**Richborough Connection Project
Effect of the Application on the Broad Oak Reservoir
Proposal
Second Issue Specific Hearing**

Wednesday 28 September 2016

Purpose of the issue specific hearing

To consider the effect of the application on the Broad Oak Reservoir proposal.

Drawing file: EN020017 / EN020017-001924-SEW - B14000AT-503 - Agreed Spot Height Plan as requested at Issue Specific Hearing on 29 July 2016.pdf

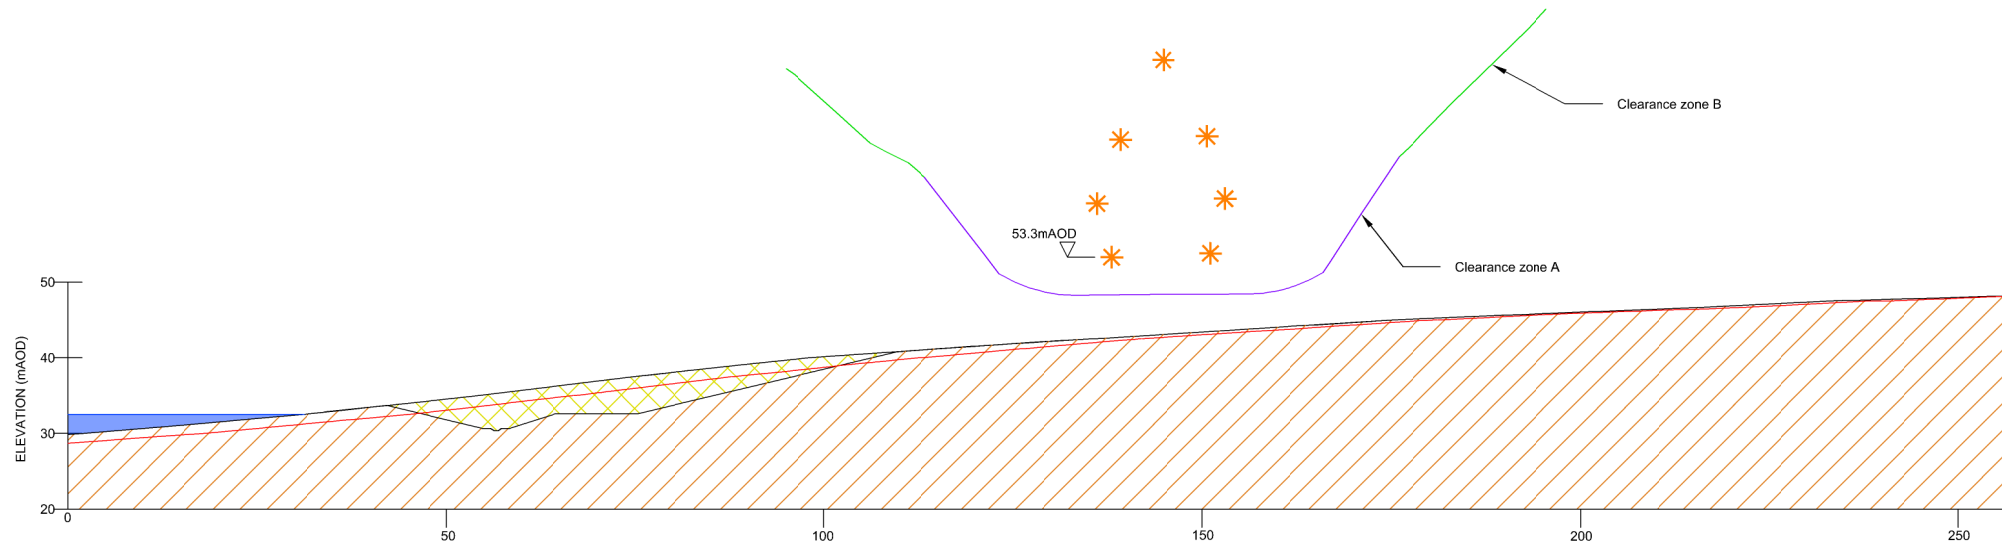
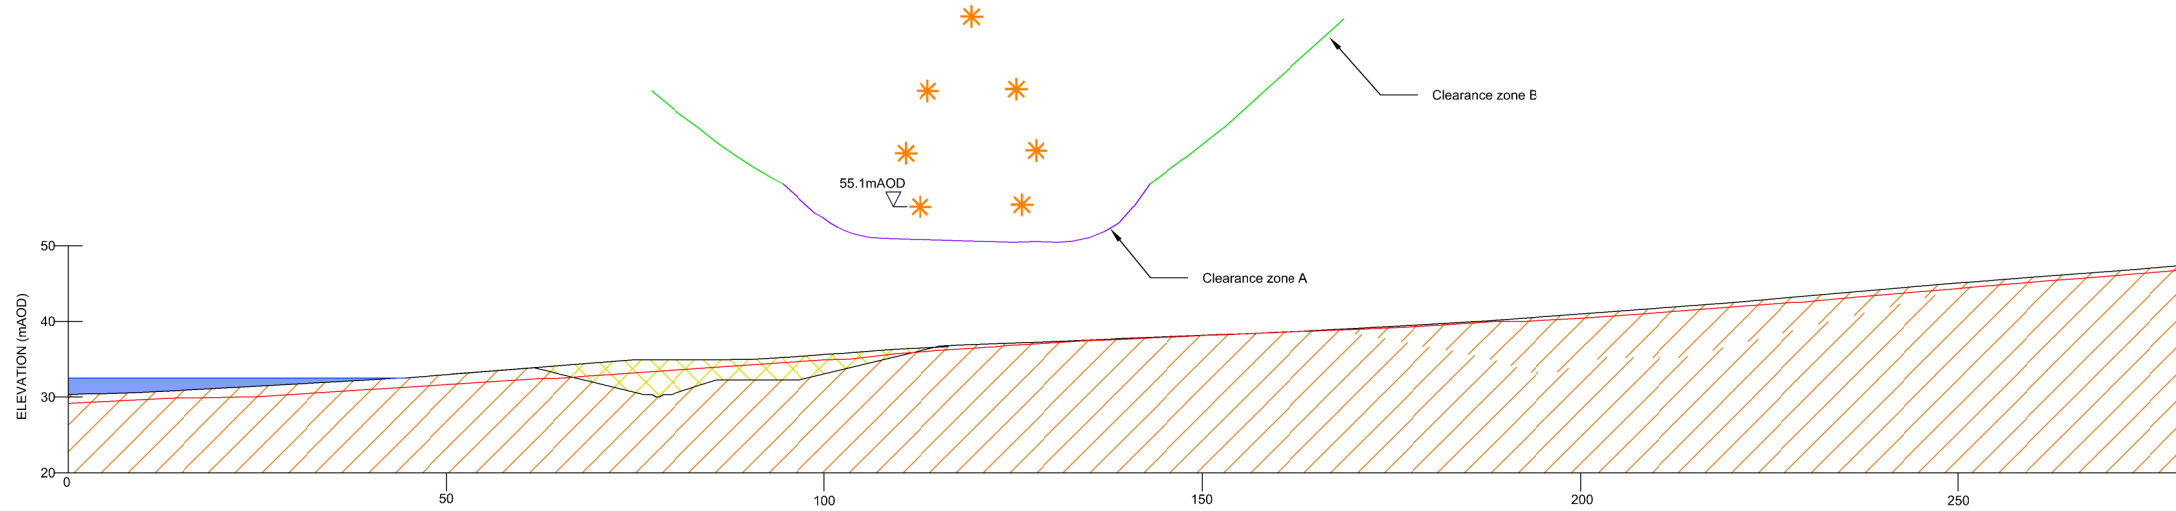
- 2.10 The relationship between mature, and minimum that would be appropriate, tree heights and spot level to clearance zone distances [Drg. B14000AT-503 et al].

- 2.11 The relationship between the indicated cable positions and those positions possible under the compulsory acquisition powers in the draft DCO [Drg. B14000AT-503 et al].
- 2.12 Future activities within the pylon exclusion and maintenance zones together with the extent of pylon foundations in the context of the submitted cross sections [Drg. B14000AT-502 et al].
- 2.13 Whether pylon PC10 can be relocated further east to avoid the proposed fish pass route with a pylon height adjustment to maintain mid-span cable clearances [Drg. B14000AT-606].
